# CITY OF ALBUQUERQUE

August 28, 2012

**Re: Mountain America Credit Union Grading & Drainage Plan, (D20-D010A)**  
Parcel B, Parcels A, B & C Ventura Plaza **P.E. Stamp: 5/18/12**

SHEET TITLE: **GRADING PLAN**
SHEET NUMBER: **C-201**
PROJECT: 2013.0048 ORIGINAL ISSUE: 05/19/2012
D20/DC10A 1-13

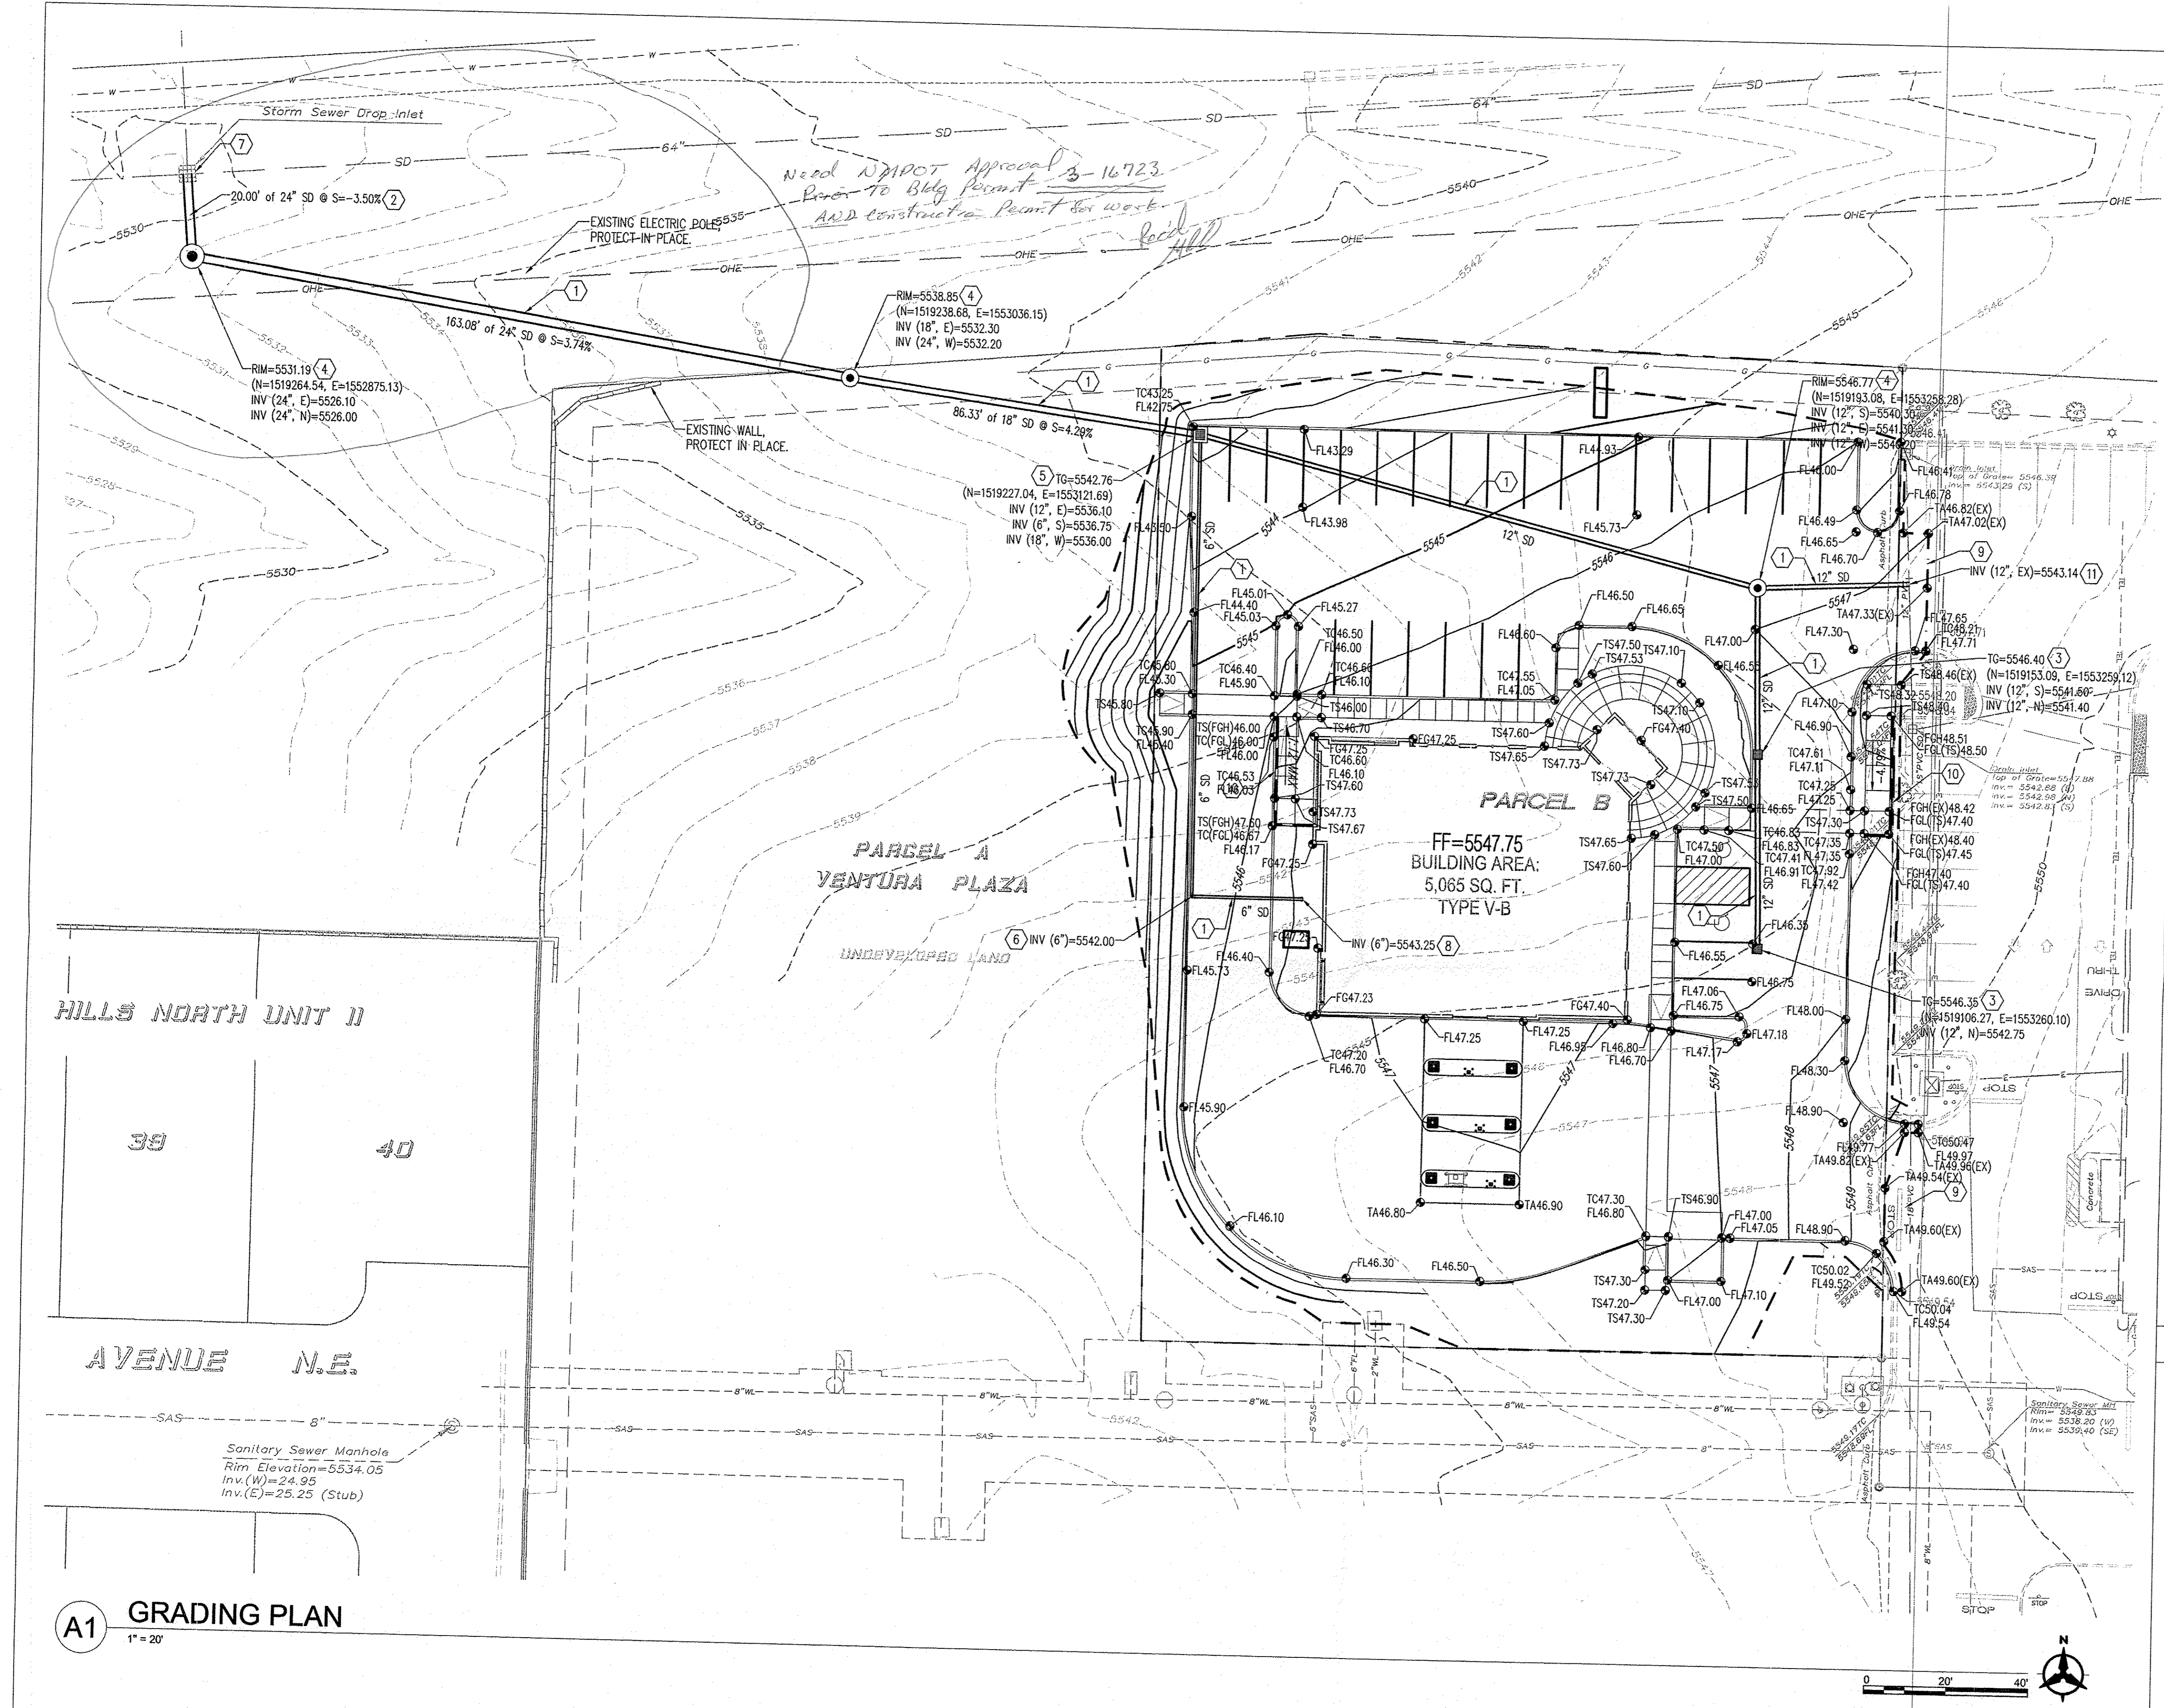
1. This plan lacks a few presentation features required for Grading and Drainage Plans, per the DPM Chapter 22. Please review the criteria, and update future submittals. For this site, I ask that you at least add a location map to the as-built Certification Plan.
2. We will require documentation from NM-DOT of their acceptance of the storm drain connection at the NW corner of the site, authorized under NM-DOT Permit # 3-16723.
